Subject: Rezoning Petition Review

Date of Review: January 26, 2023

Rezoning Petition #: 2022-134

Location of Property: Approximately 16.37 acres located northwest of Steel Creek Road and east of Outlets Blvd along Trojan Drive

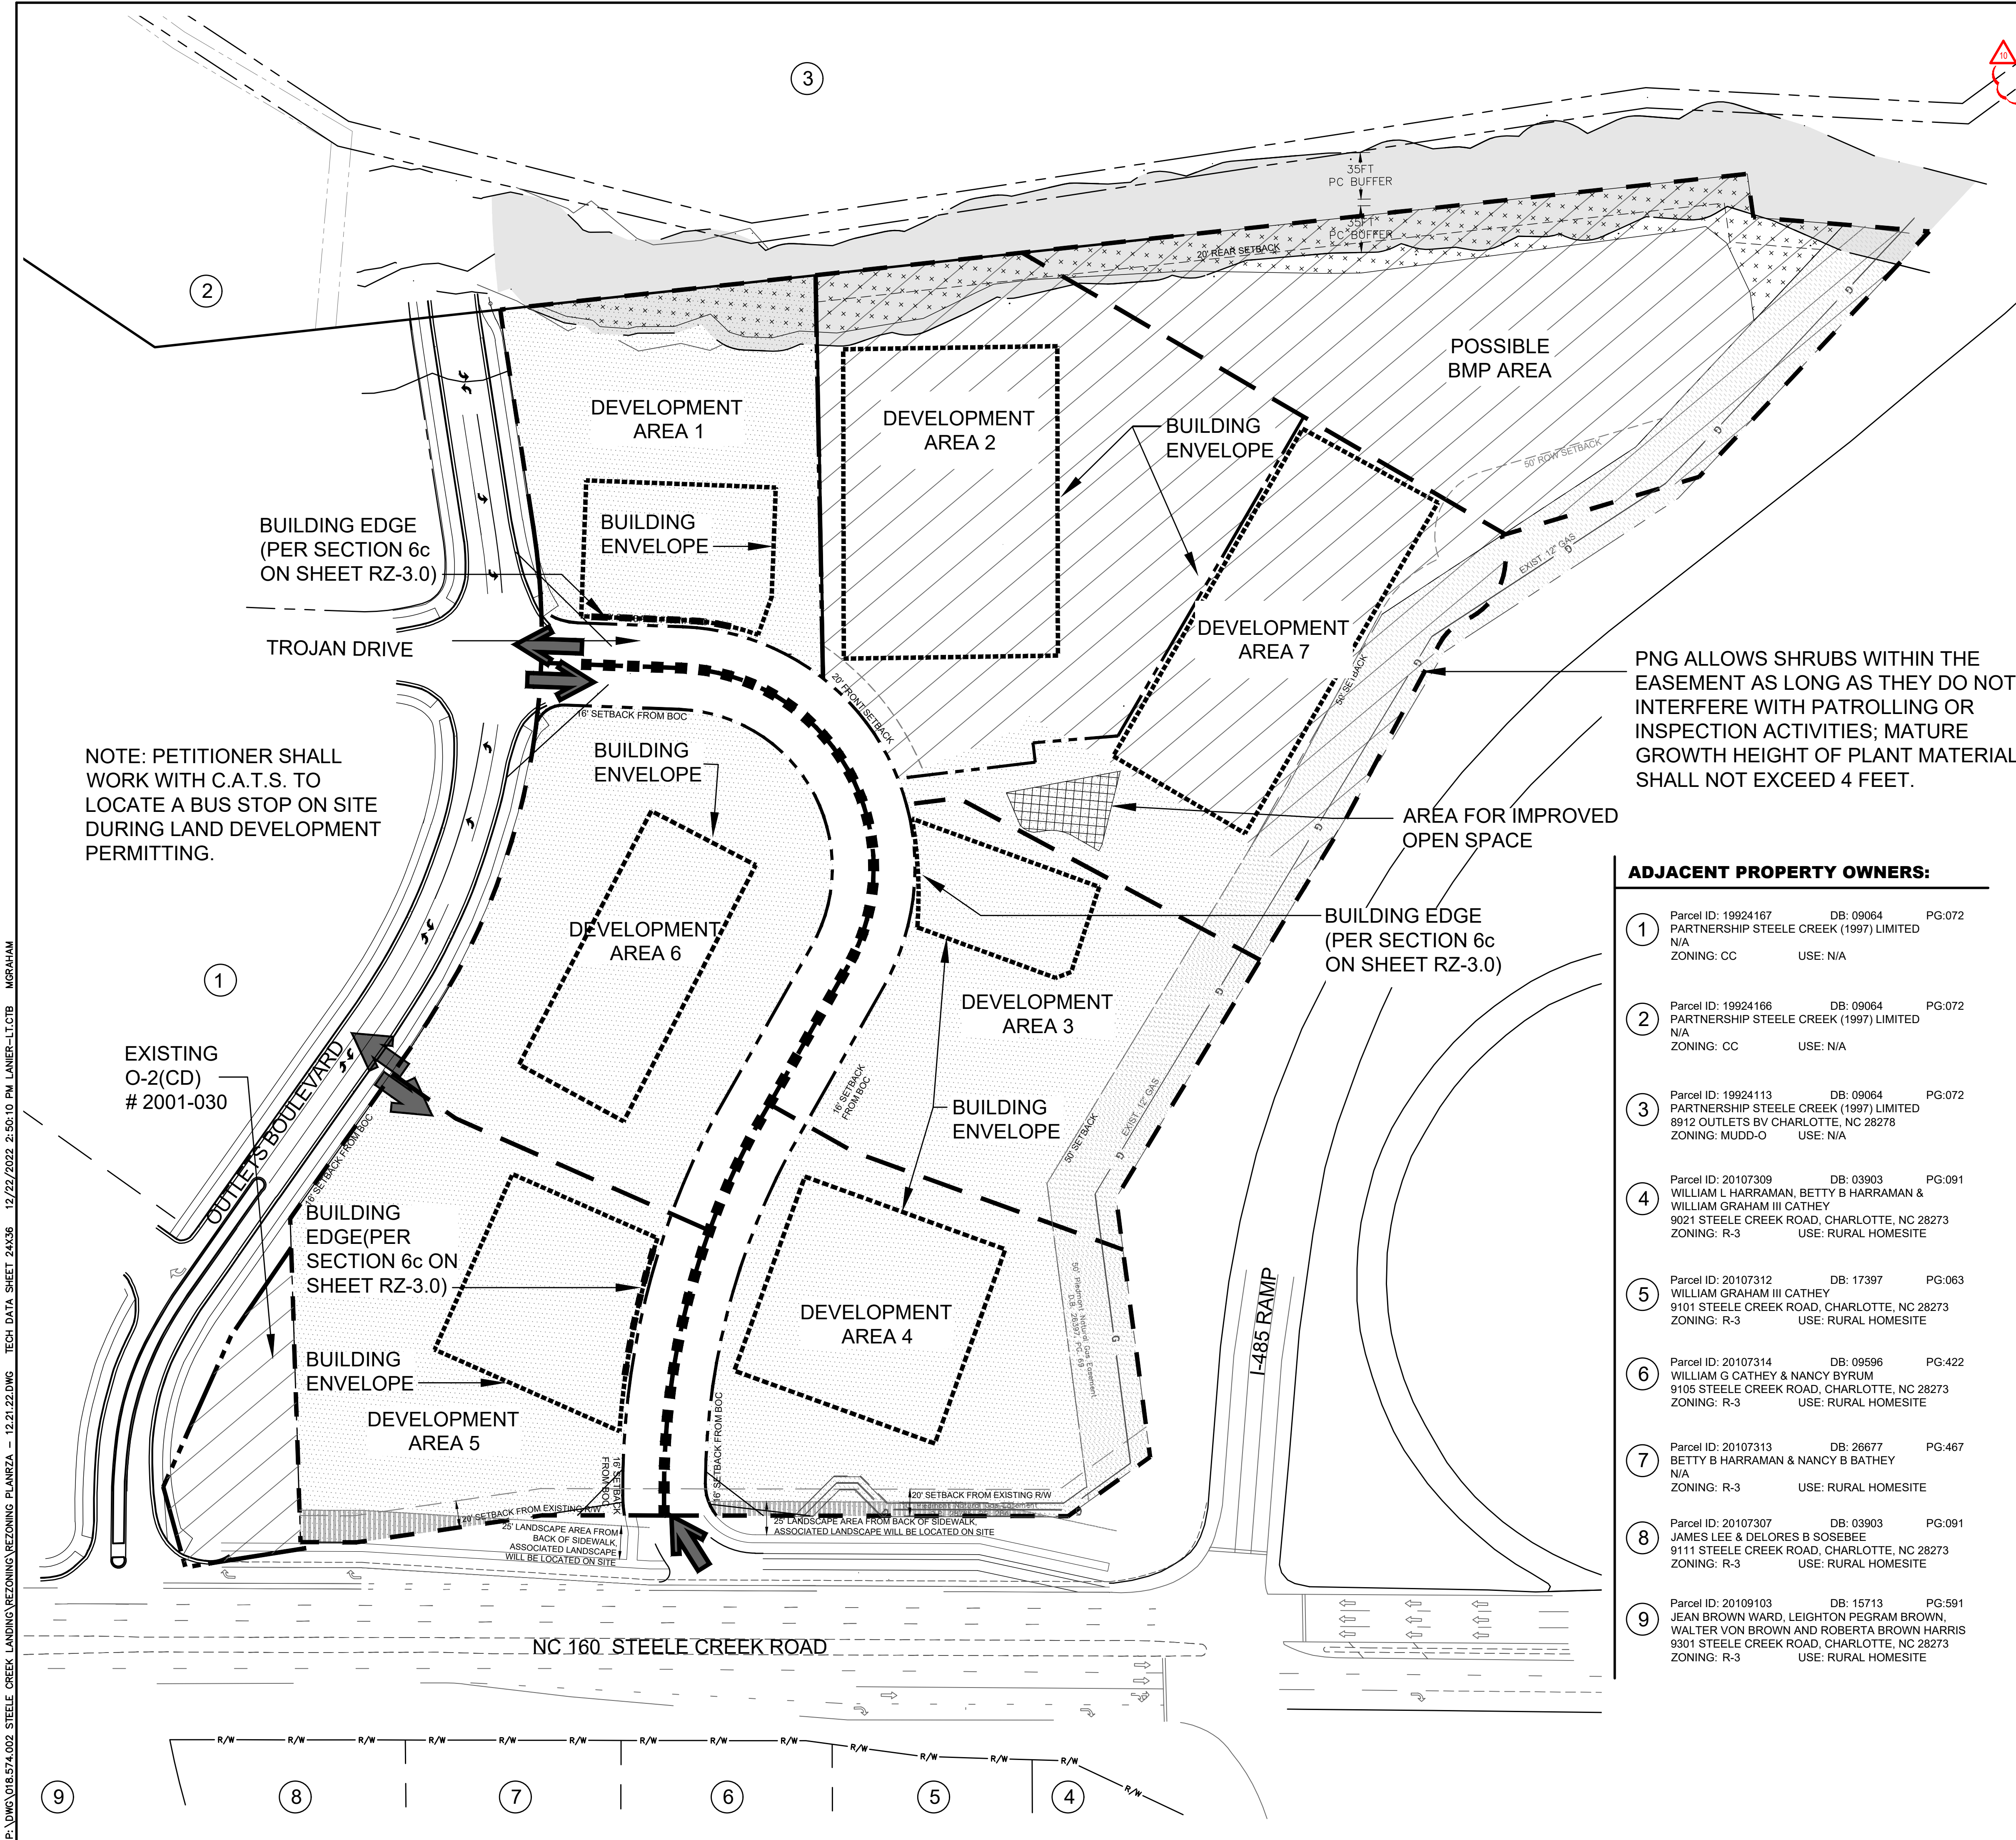
Perennial and intermittent streams delineated on the rezoning plan are subject to stream buffer requirements. Please show most restrictive buffer requirements per Lower Lake Wylie Watershed Overlay (Charlotte Zoning Ordinance) and Post-Construction Stormwater Ordinance, and adjust construction/disturbance limits accordingly.

City of Charlotte GIS data indicates a Lower Lake Wylie Protected Area Watershed Buffer on site. Please note depending on the project density this could be a 40-ft or 100-ft Watershed Buffer and subject to Watershed Overlay District requirements.

Please label width of all potential stream buffers on rezoning plan, including the Undisturbed Watershed Protection Buffer for the Lower Lake Wylie Protected Area. Depending on project density, the Undisturbed Watershed Buffer can vary from 40' to 100' and should be labeled as such on the rezoning plan.

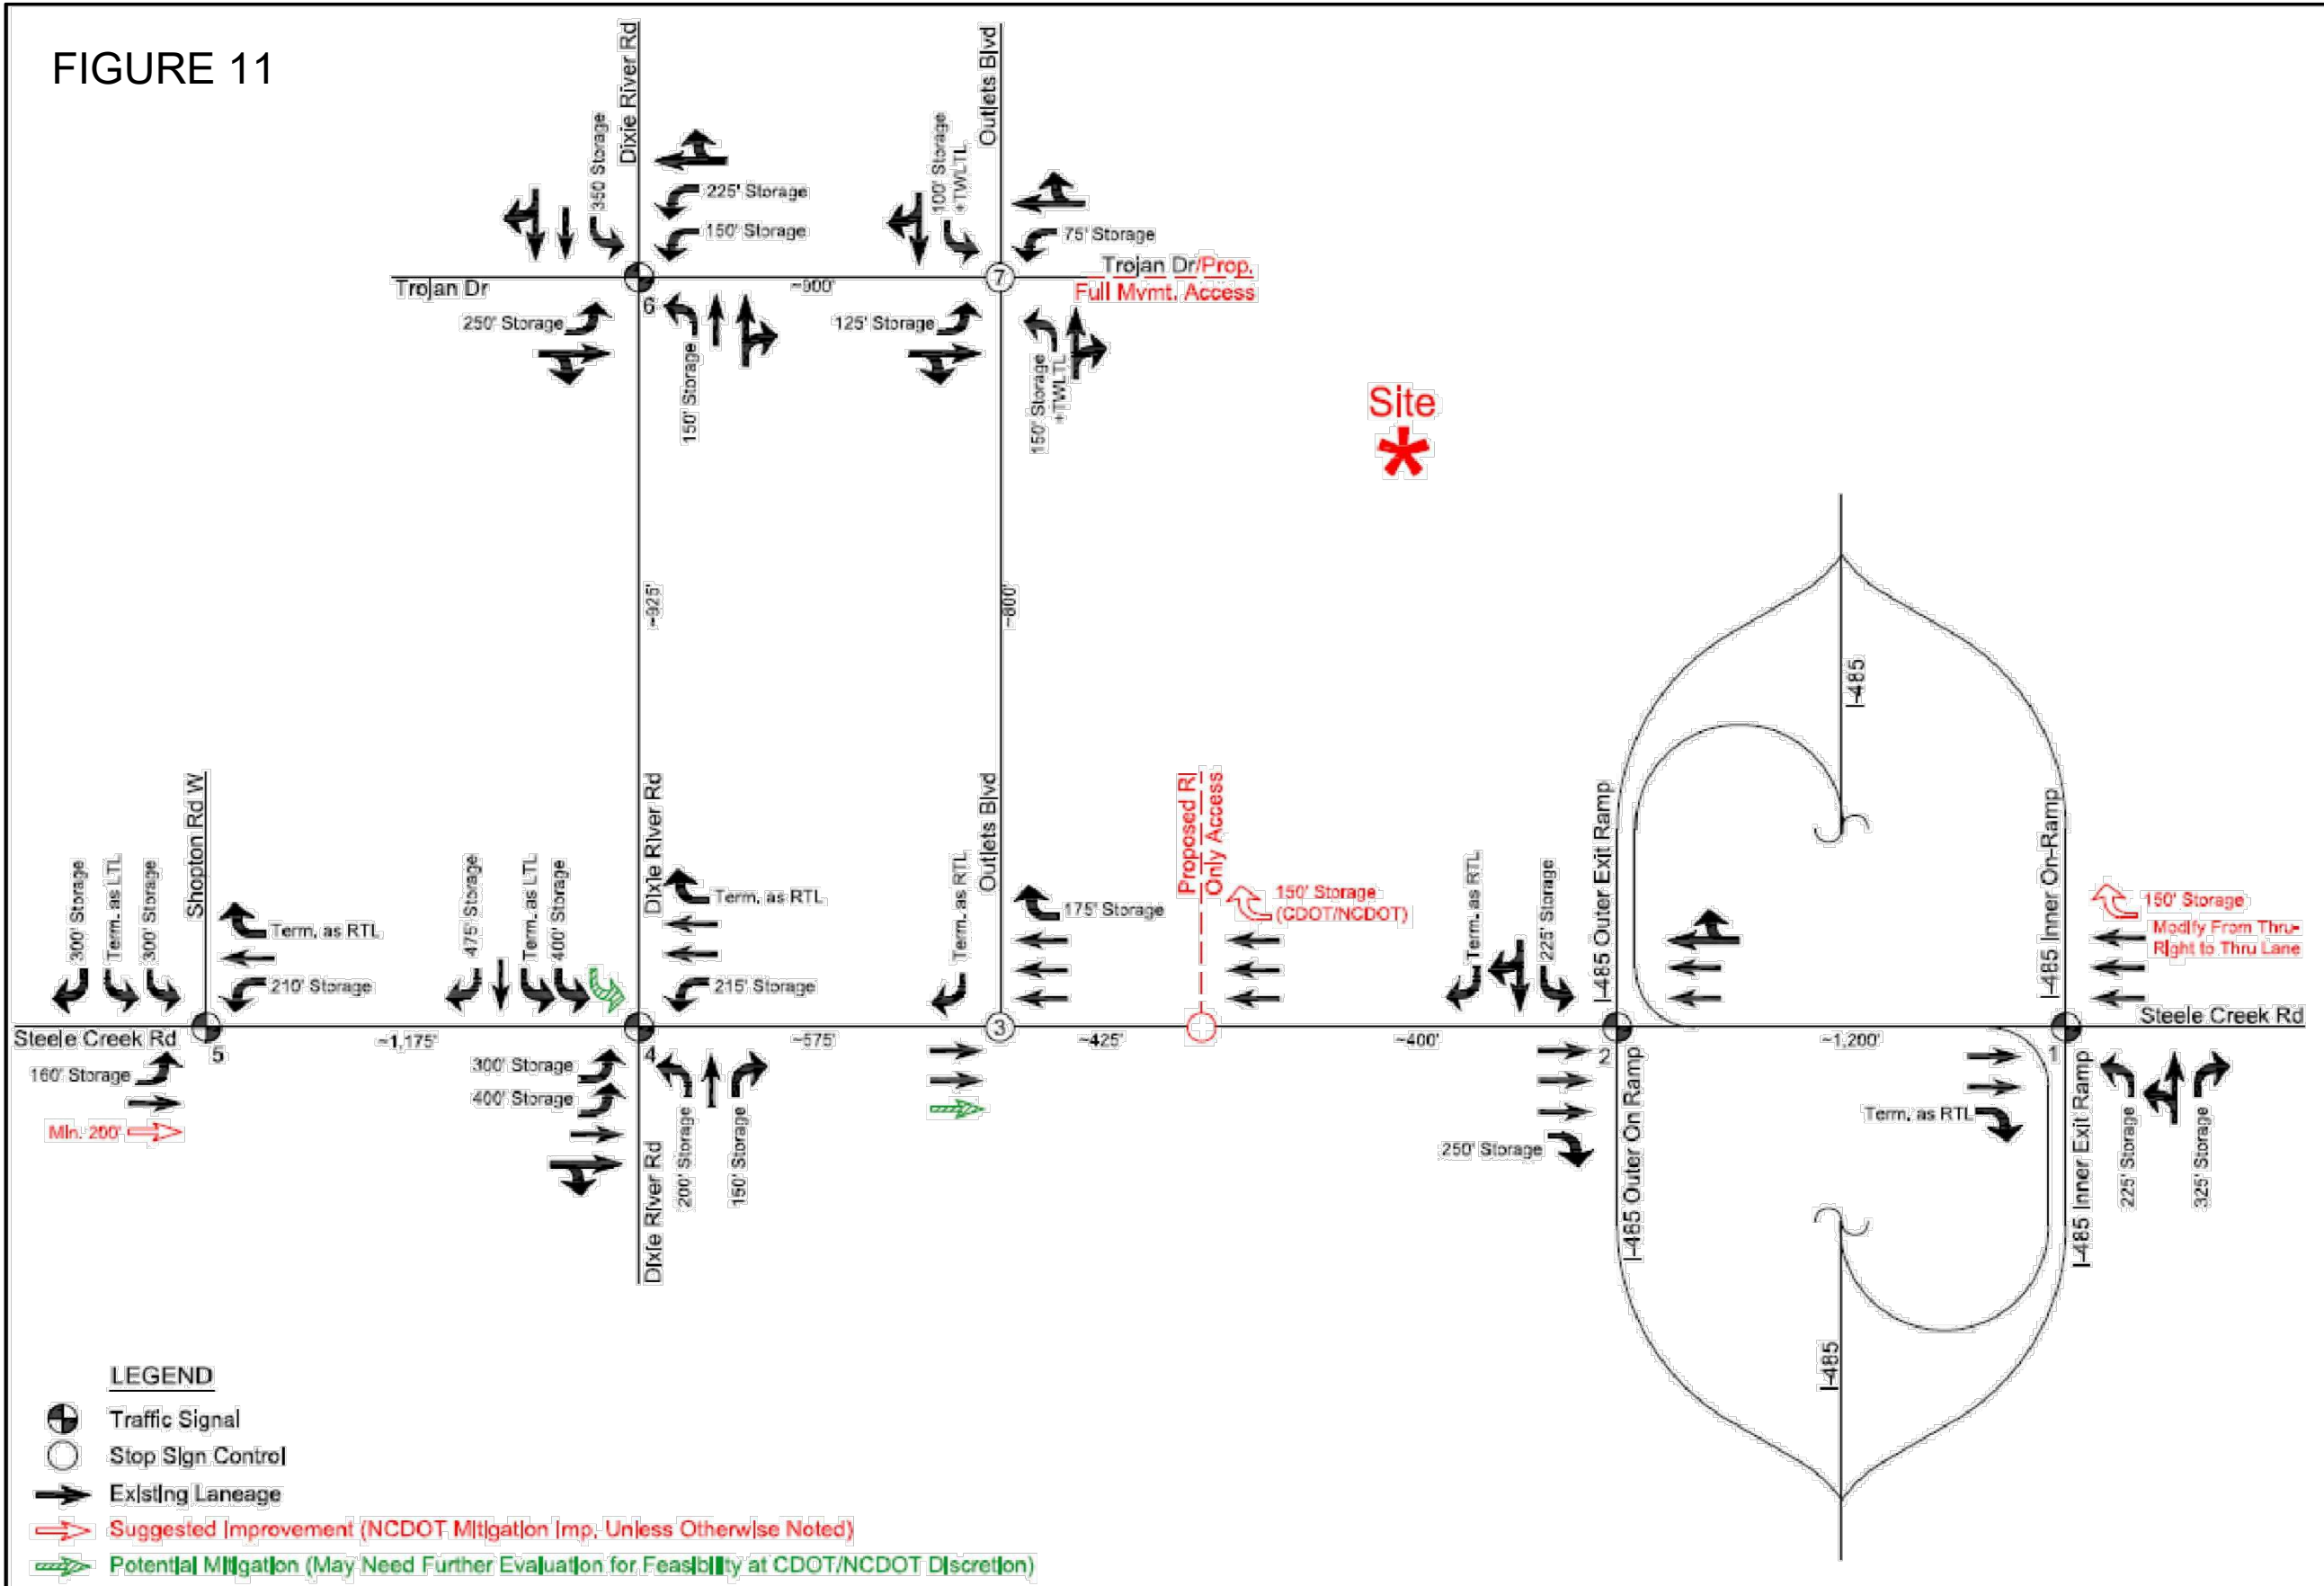
Please remove note 7c under "Environmental Features". Vegetation and landscaping requirements for storm water control measures are not approved with the rezoning process. These are based on the BMP Design Standards Manual, including the planting type, spacing and placement.
